CITY OF ALBUQUERQUE

March 2, 2012

**Re: Gate of Heaven Cemetery
Site Grading Plan
Engineer's Stamp dated 6-9-12 (D19/D001A)**

PROJECT NUMBER 0702
DRAWN BY T.E/SEJ
CHECKED BY KRB
ISSUE DATE 1-9-12
FILE NAME: 0702_C-103_SITE GRADING PLAN
SHEET NAME
SITE GRADING PLAN
SHEET NUMBER
C-103

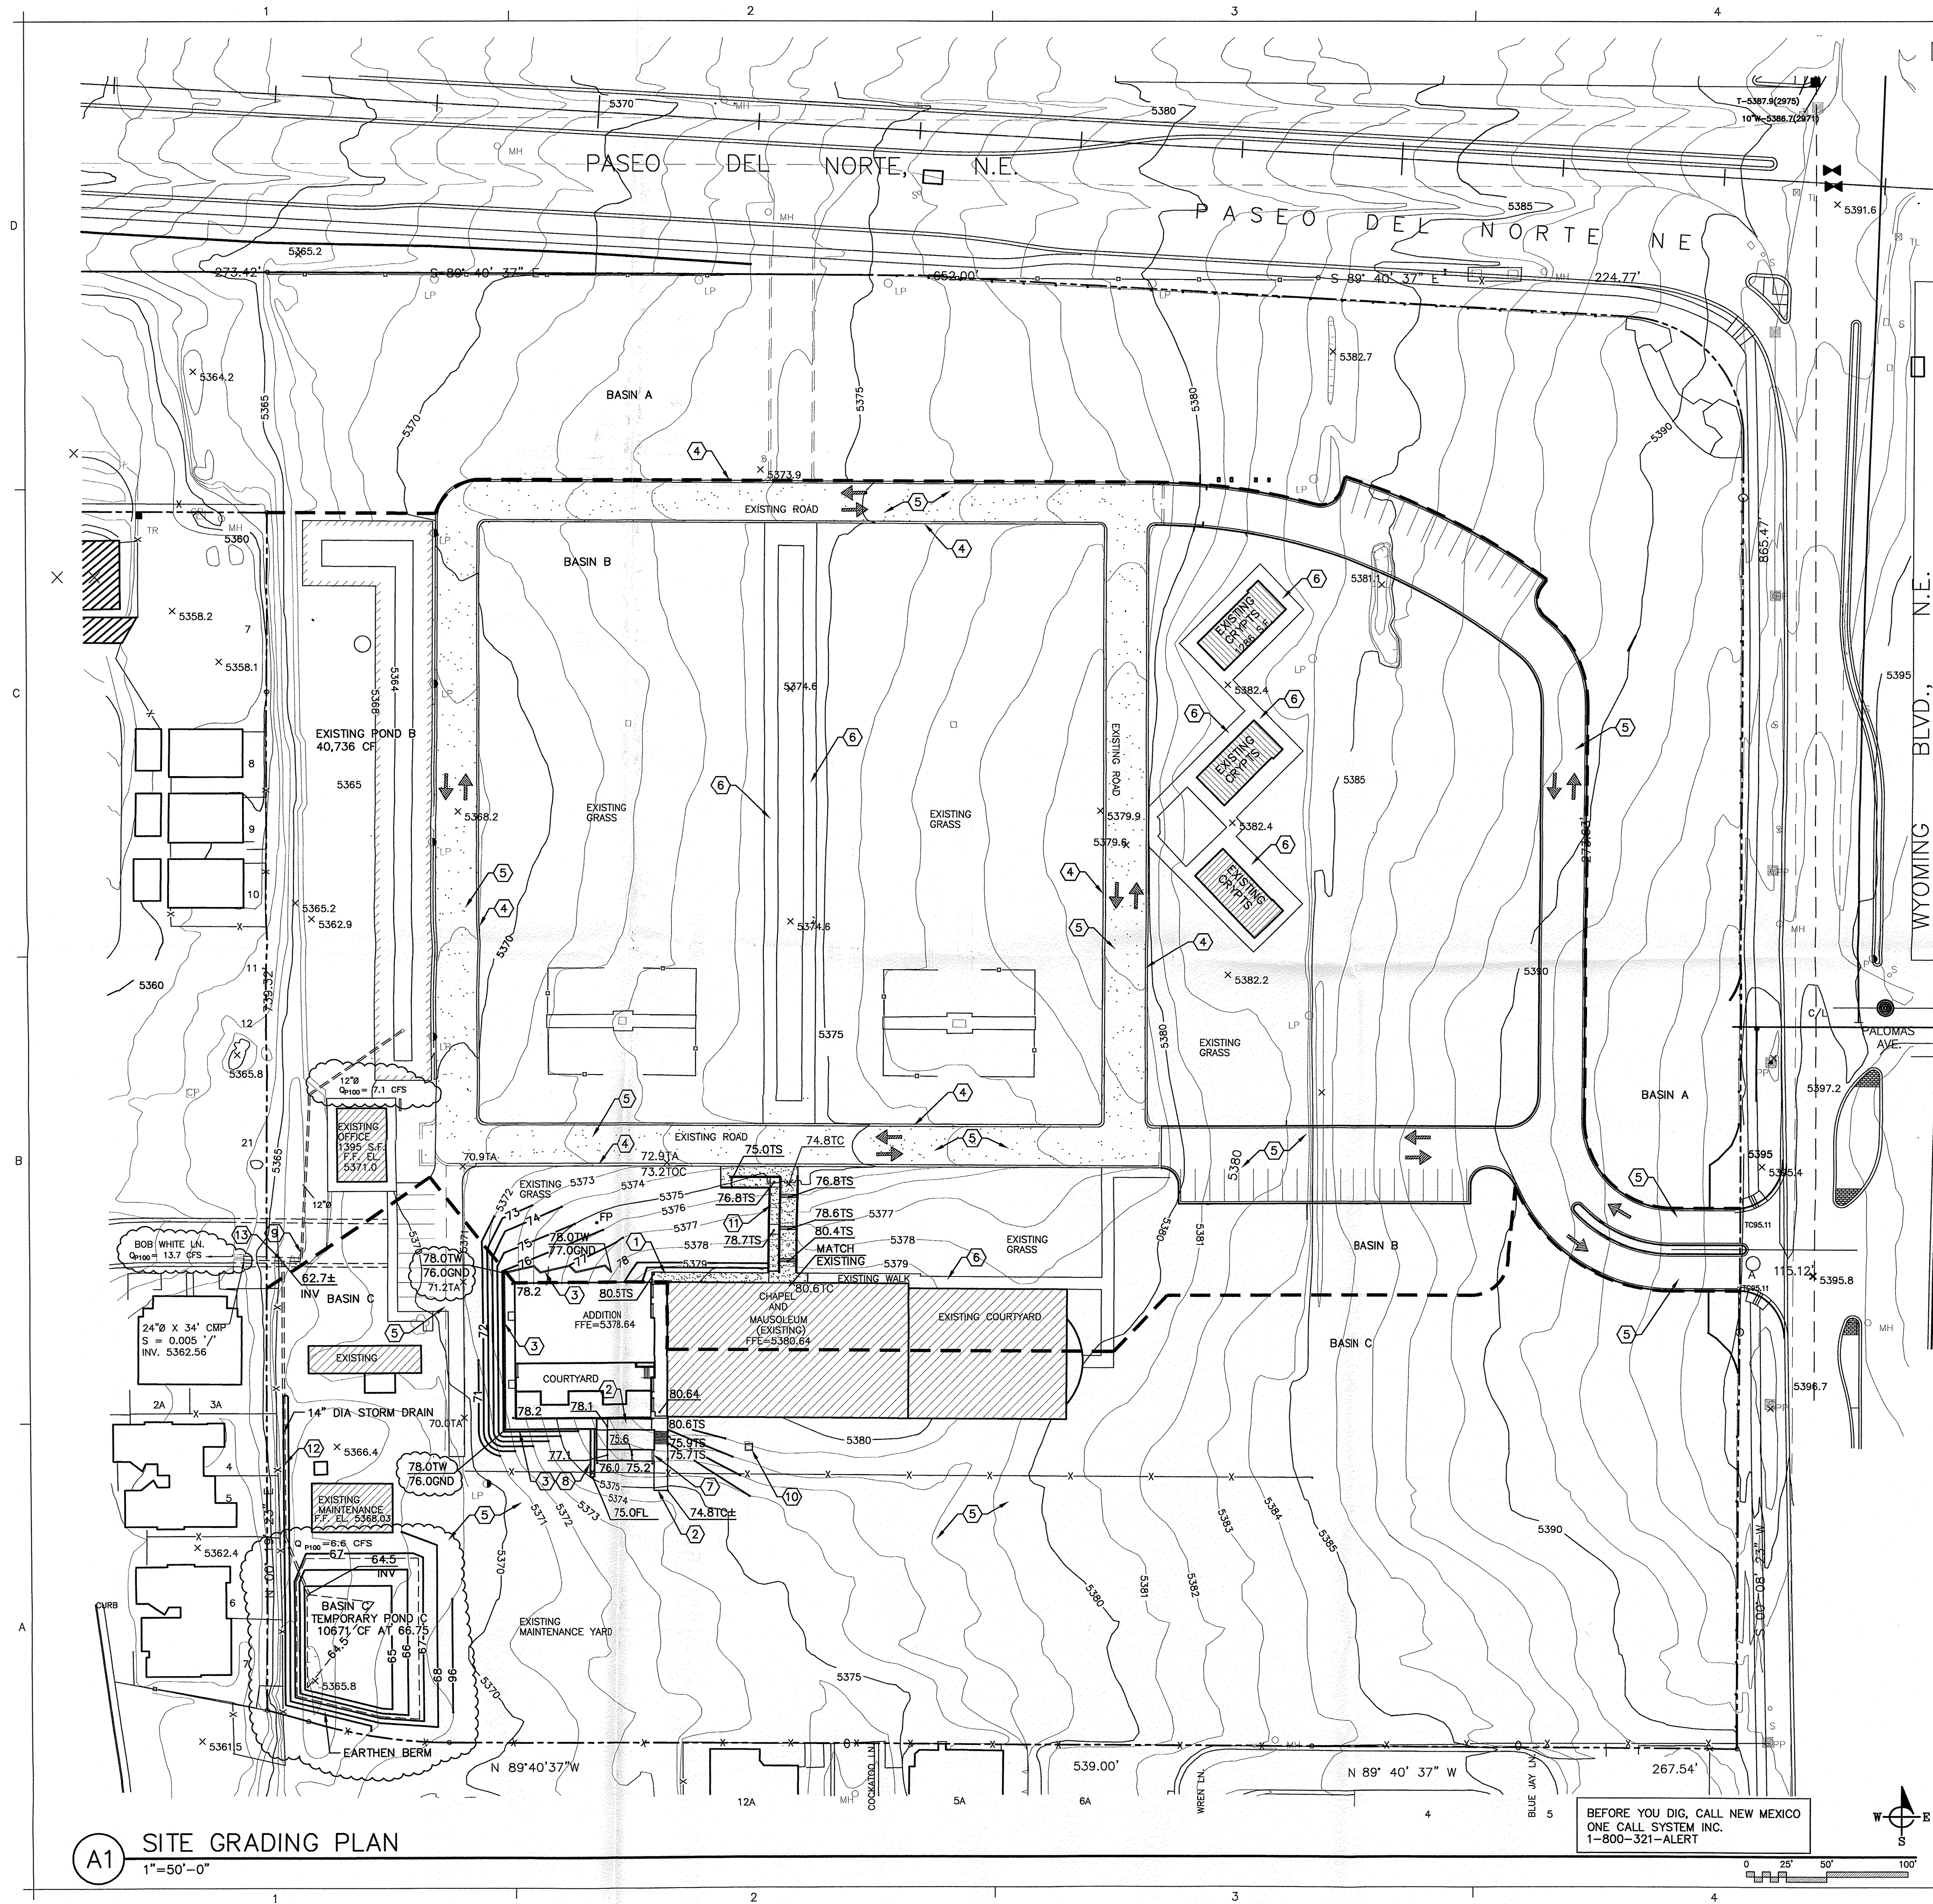
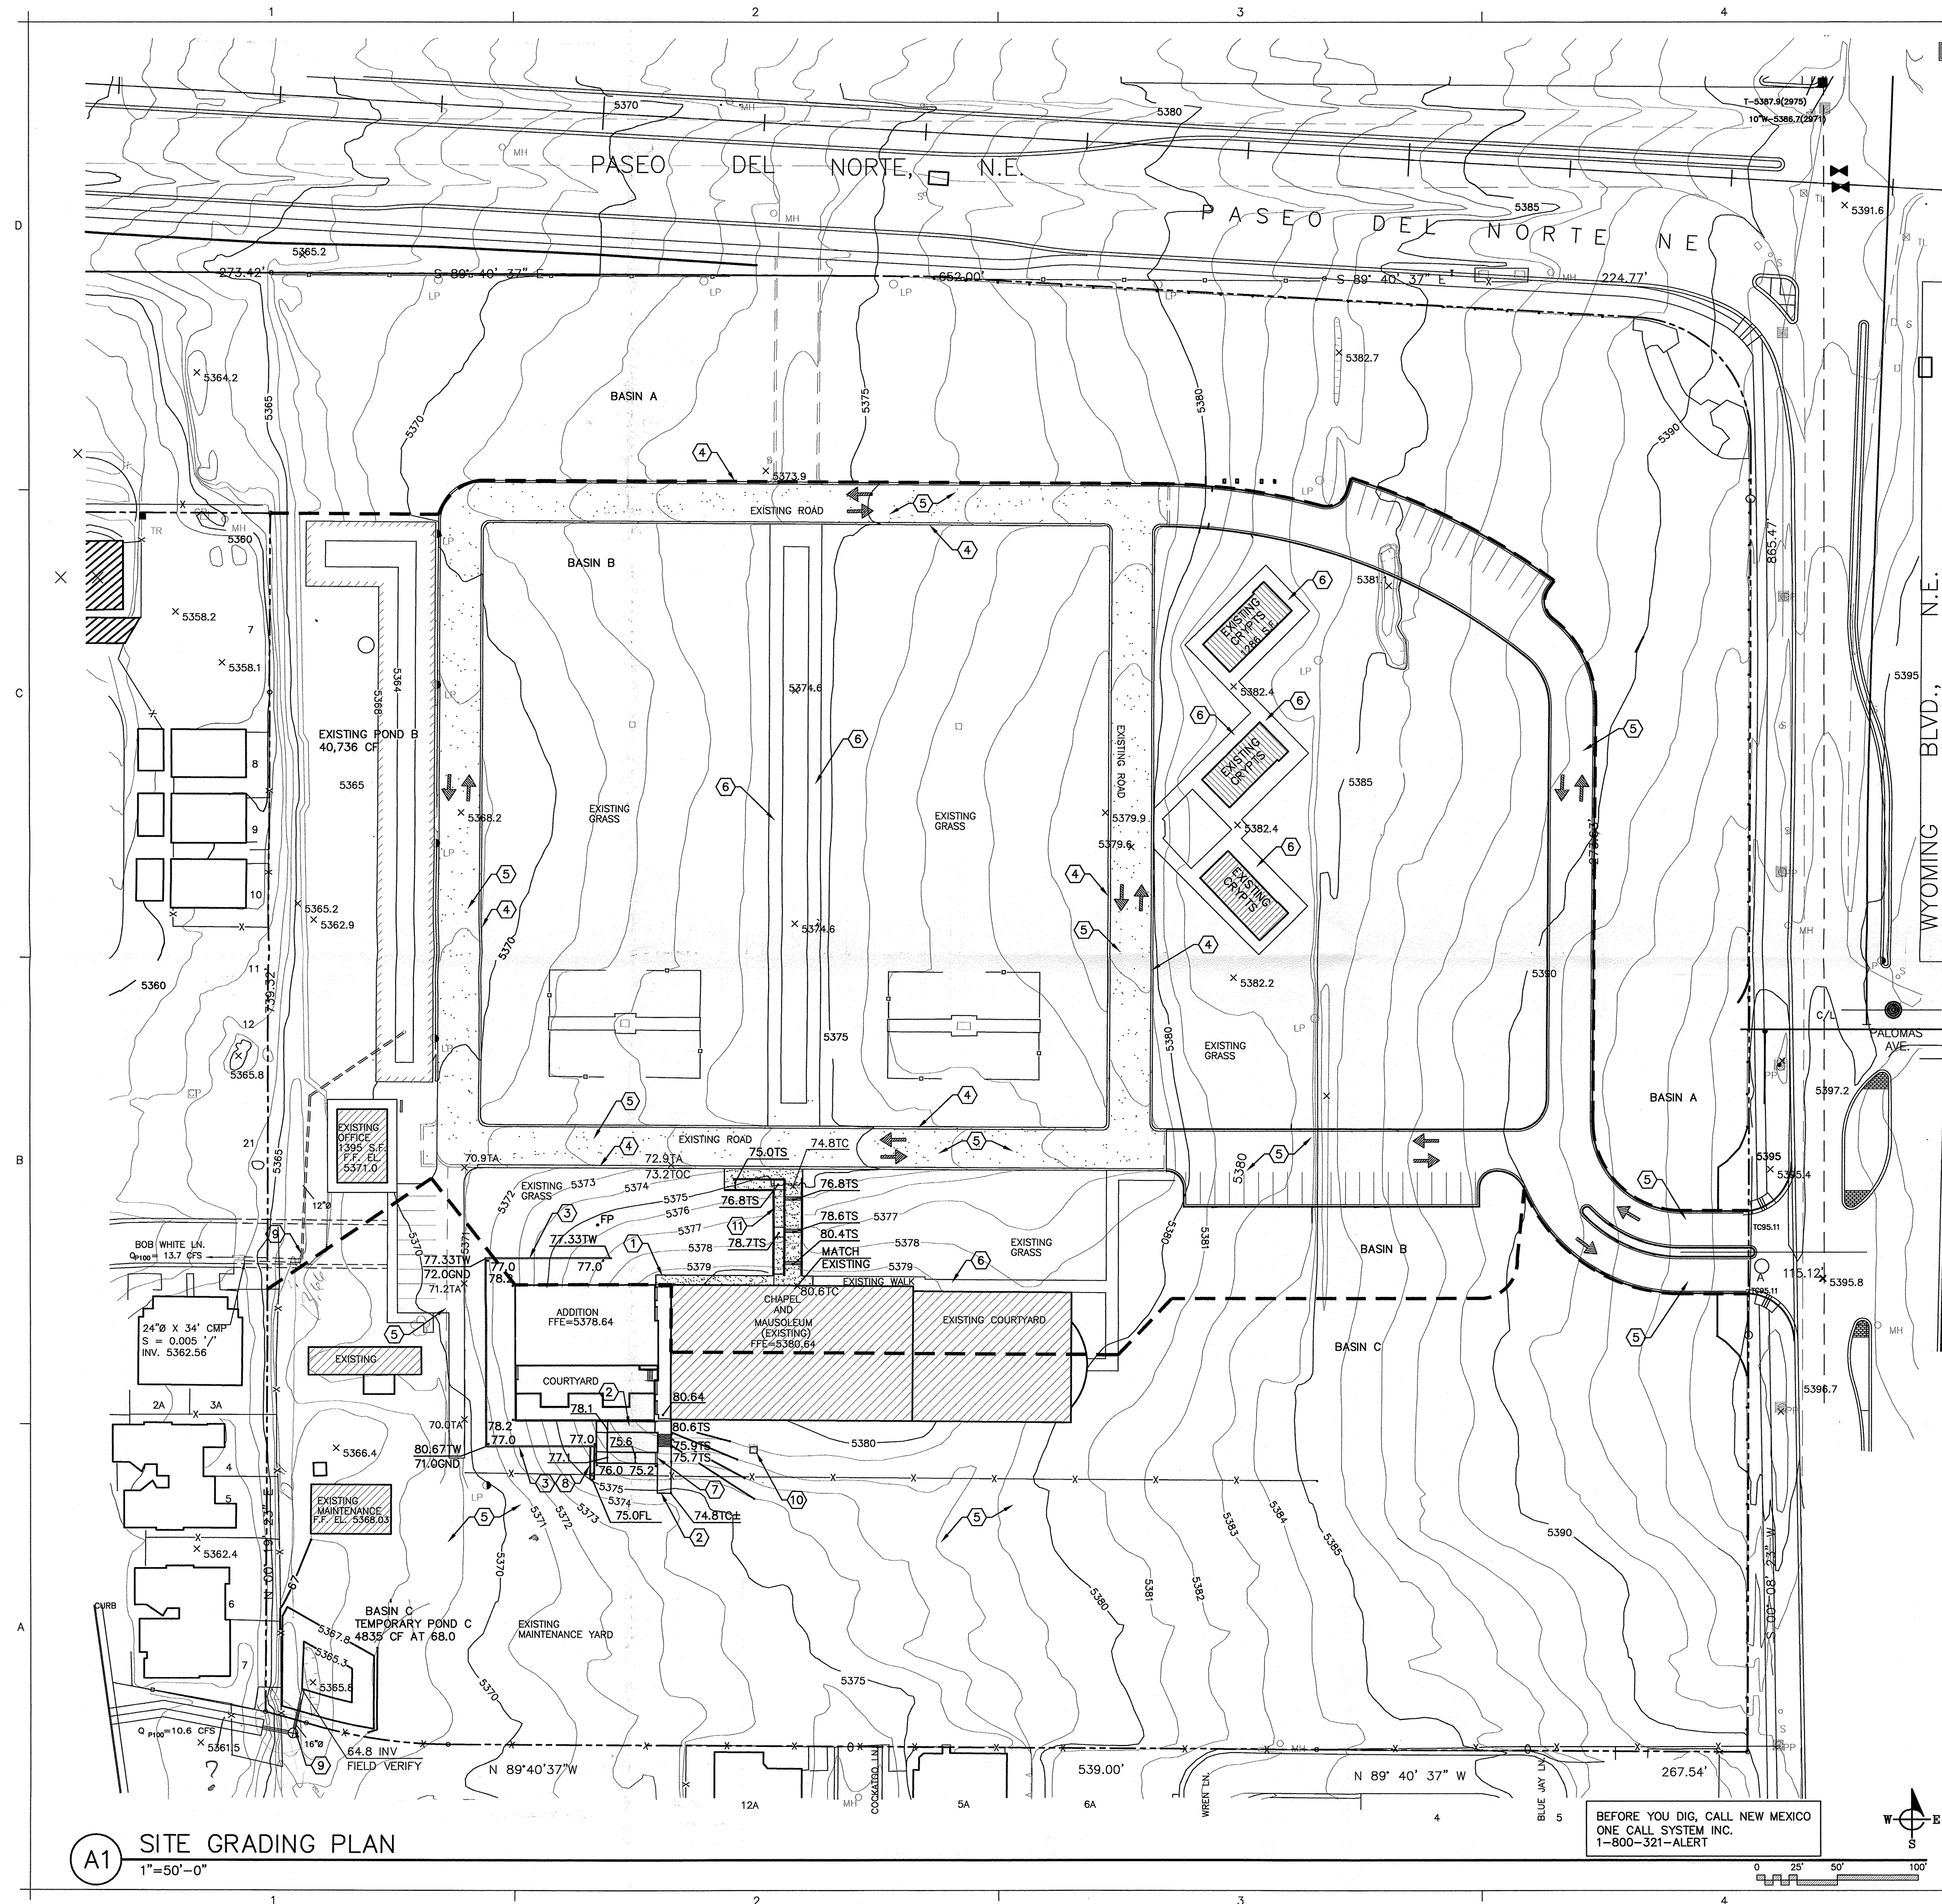
- Per approved grading plans dated 6/4/2002 and 11/21/94 basins B & C were to drain into ponds B & C which was then piped to the outfall at Bob White Lane at a rate of 13.7cfs. This plan should propose the same drainage scheme.
- Provide basin, pipe and pond calculations to support the above mentioned drainage scheme.
